273 Presumpscot St - Change of use permit (Zachary Cover)

I'm in the process of reviewing a permit application submitted by Zachary Cover, for the conversion the use of the small building on Hascall & Hall's property to a medical marijuana grow business. Unfortunately, I've encountered a significant problem.

FIRST & SECOND FLOOR PLANS  
**A-1.0**

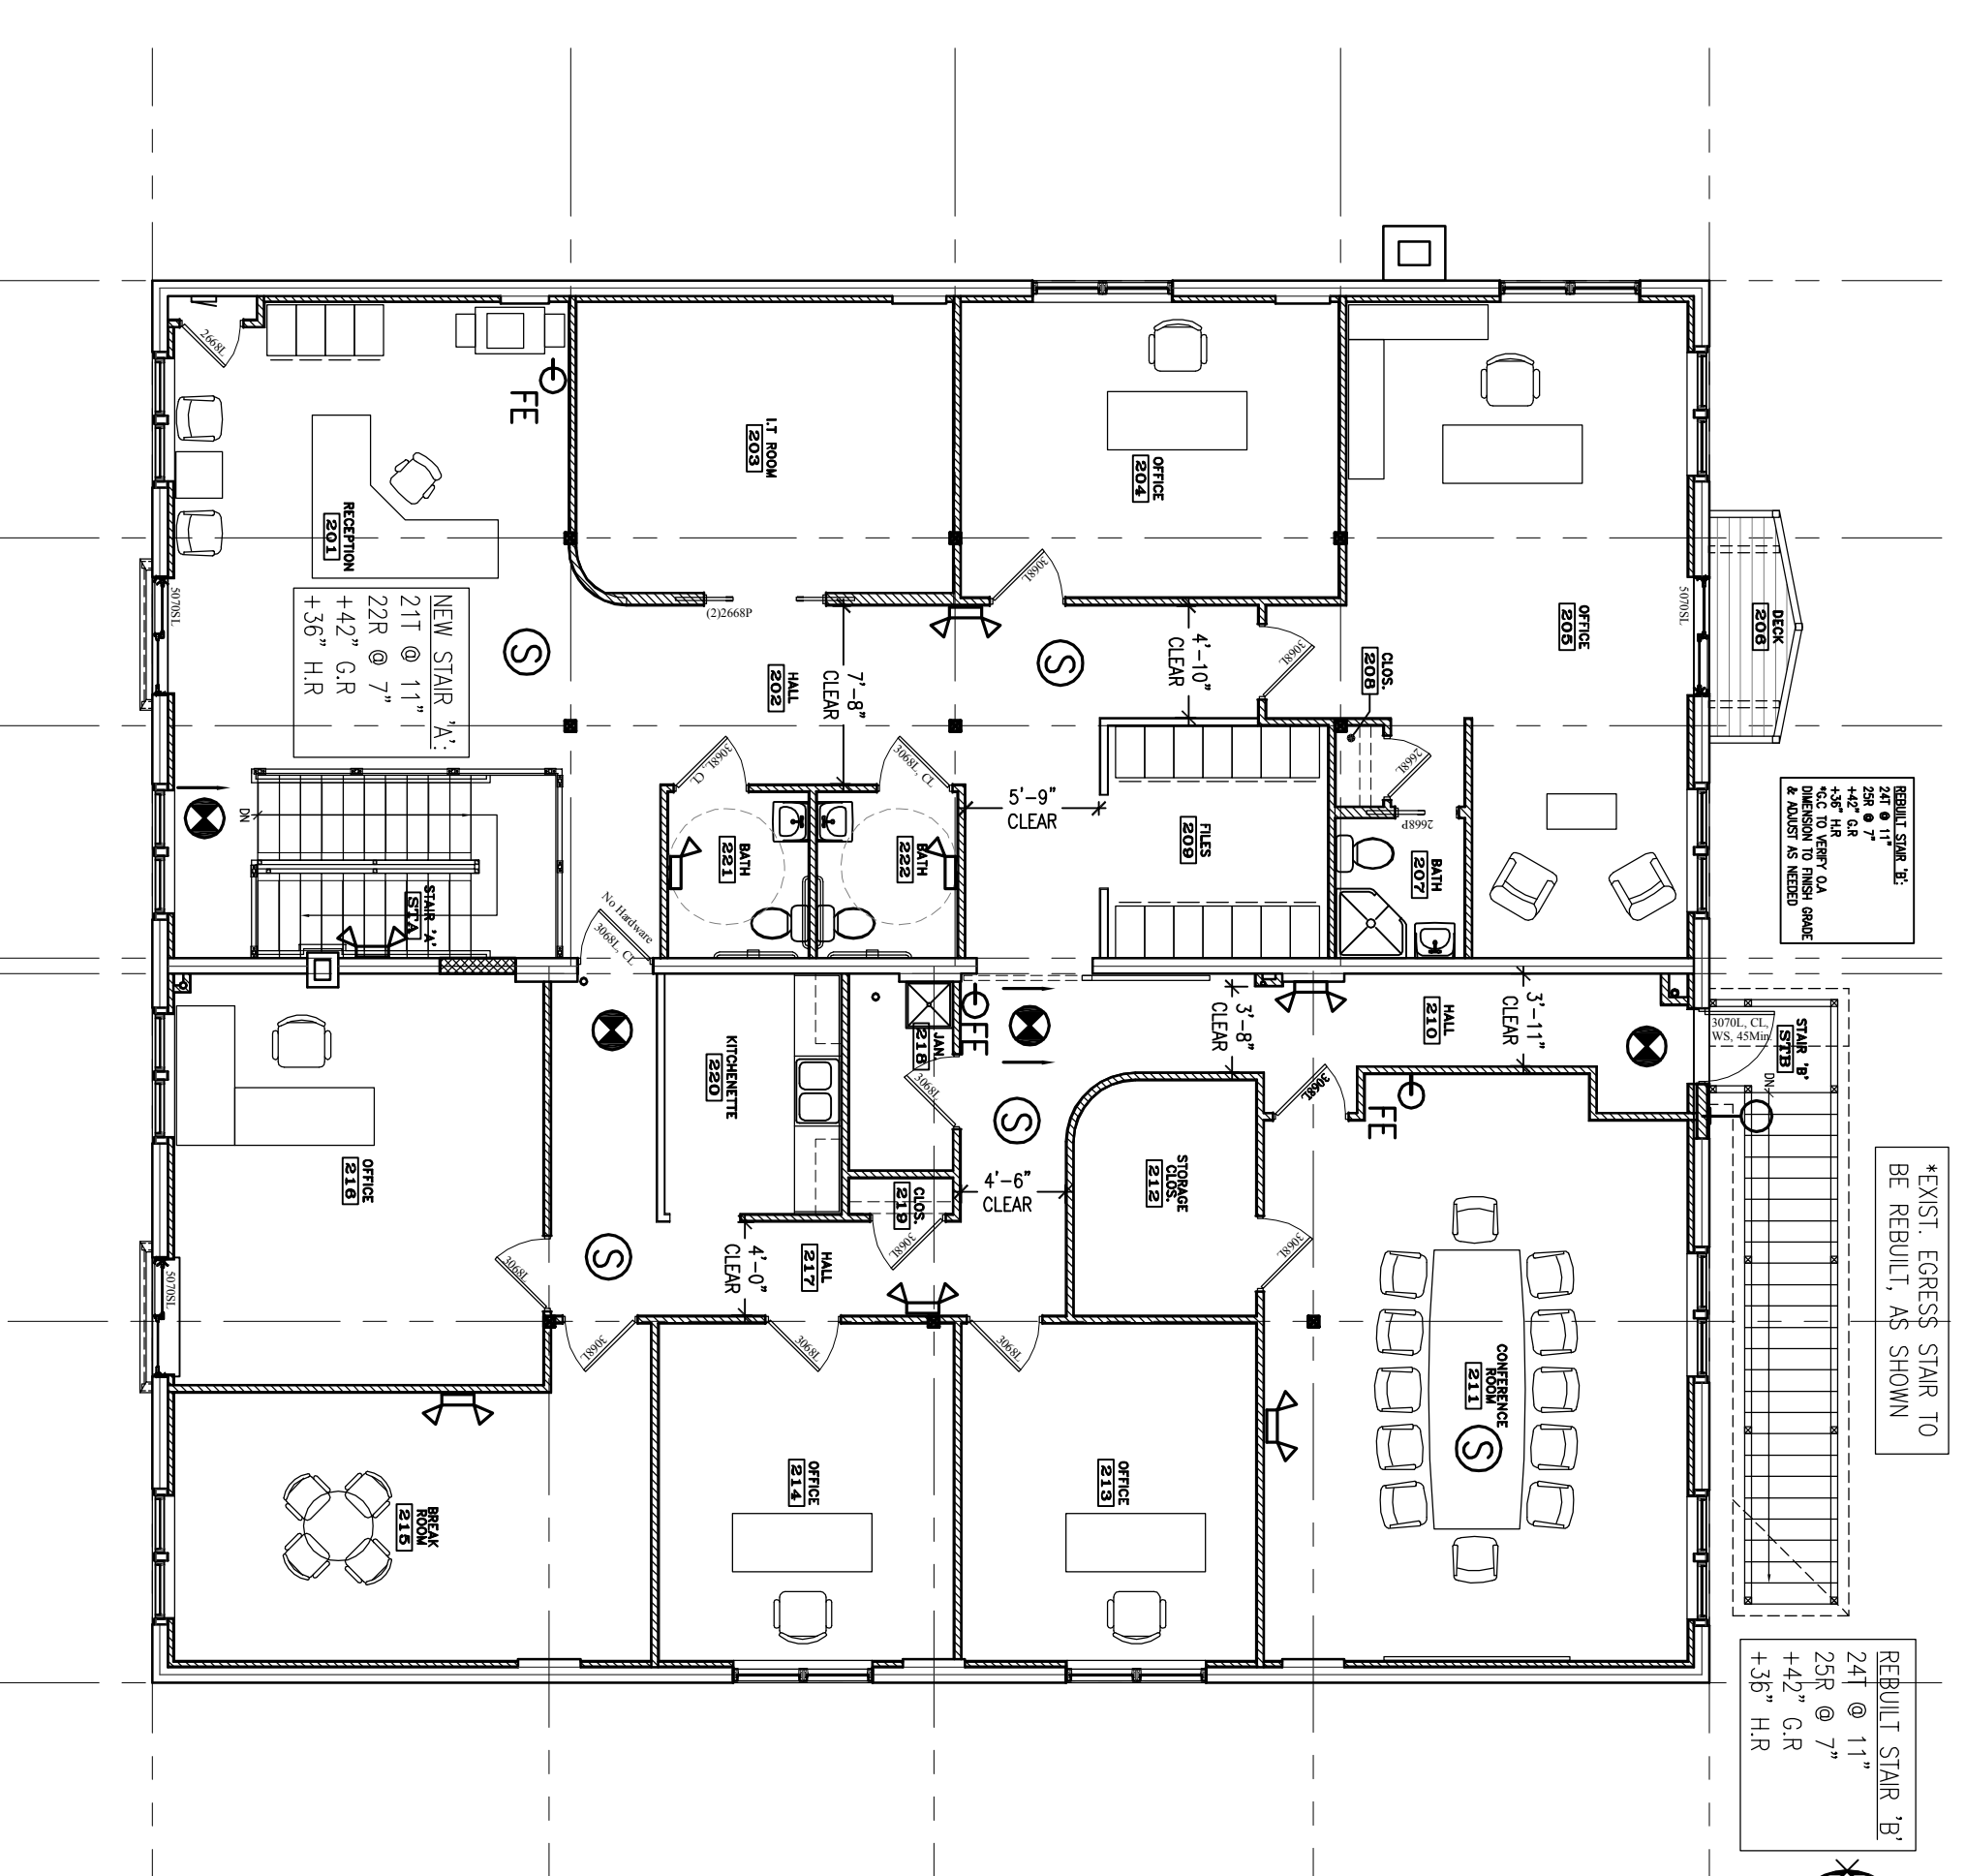
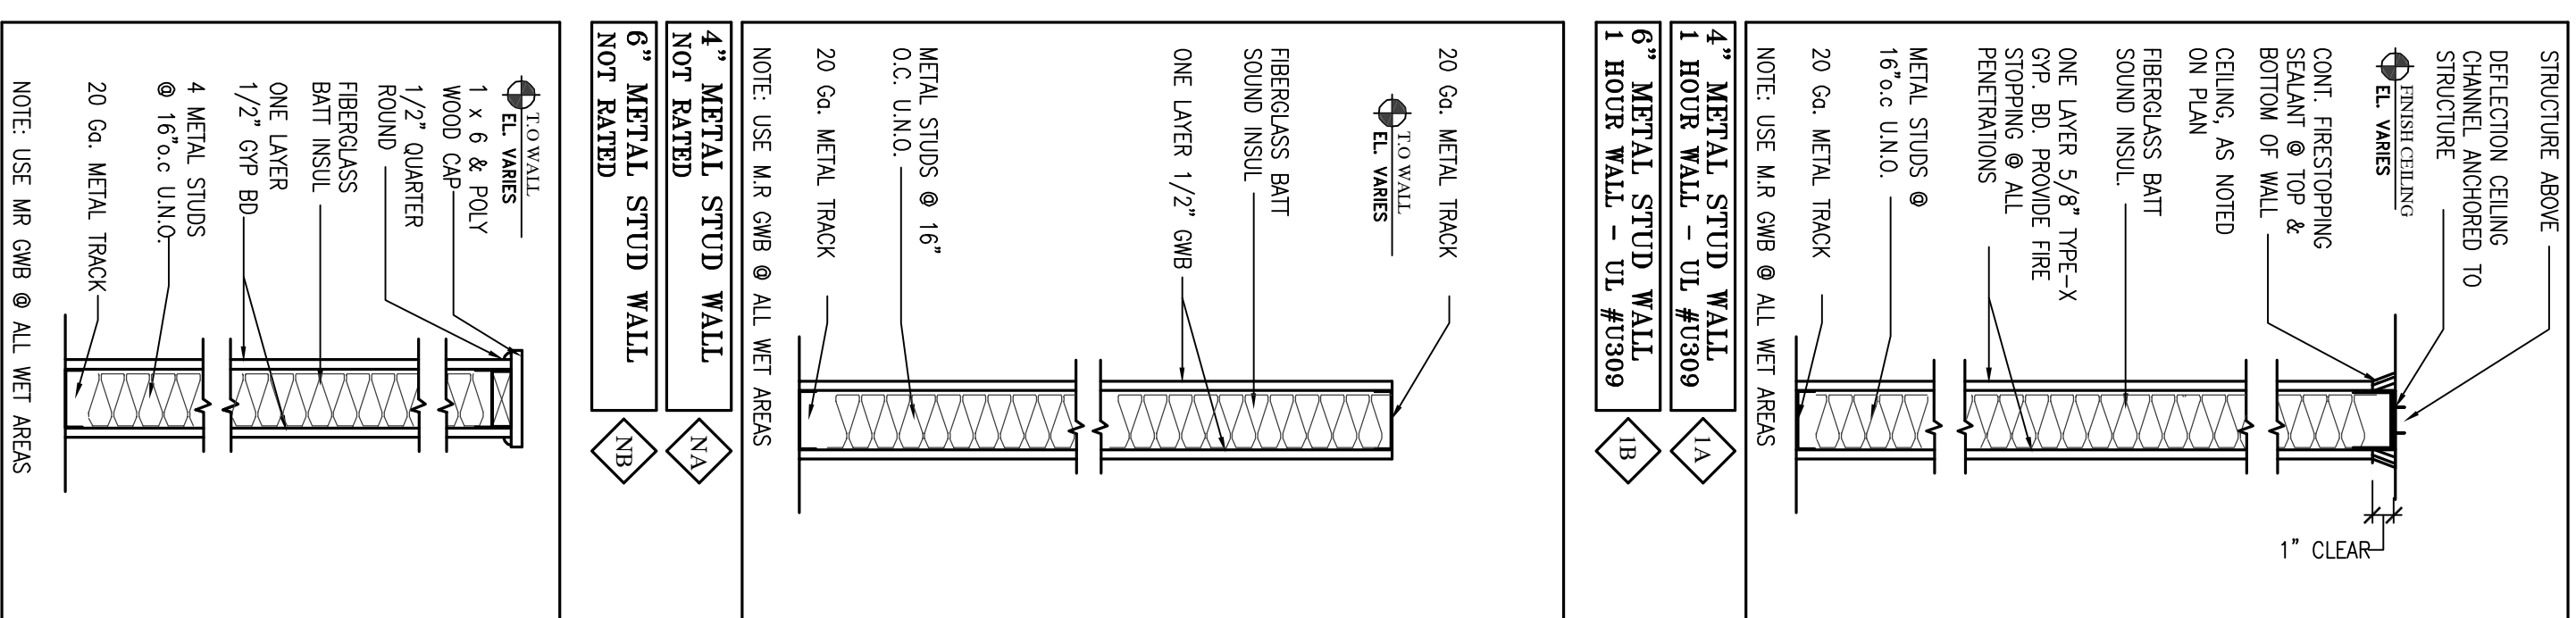
Mr. Cover's application mentions that the second floor of this building is an apartment (dwelling unit) that is to remain. I cannot find anything in the city's record that approved a dwelling unit on the property. The last permit for this building was issued in 2002 and approved the use of the both the 1st and 2nd floors as an appliance warehouse and refurbishment business (McLaughlin Appliance, Inc.). I am forced to conclude that the second story was likely converted to an apartment sometime after 2002 without appropriate city approval. The city cannot grant approval for an apartment here, because it is in the I-M Industrial Zone, which does not allow any residential uses.

In order to proceed with Mr. Cover's permit, the use of the apartment will need to be discontinued by the removal of the kitchen, including all equipment and capping the plumbing at the wall.

We leased the space to Zachary Cover for a handyman/carpentry business and a medical marijuana caregiver operation. His lease also says that he can use the second floor as a residence; however, he must obtain proper permits and that it is his responsibility to do so. As far as a kitchen goes, there has been a kitchenette there for as long as we have owned the property and was used by previous tenants for that purpose only. We see no need to remove the sink. My suggestion would be to contact Zachary Cover about the second floor space.
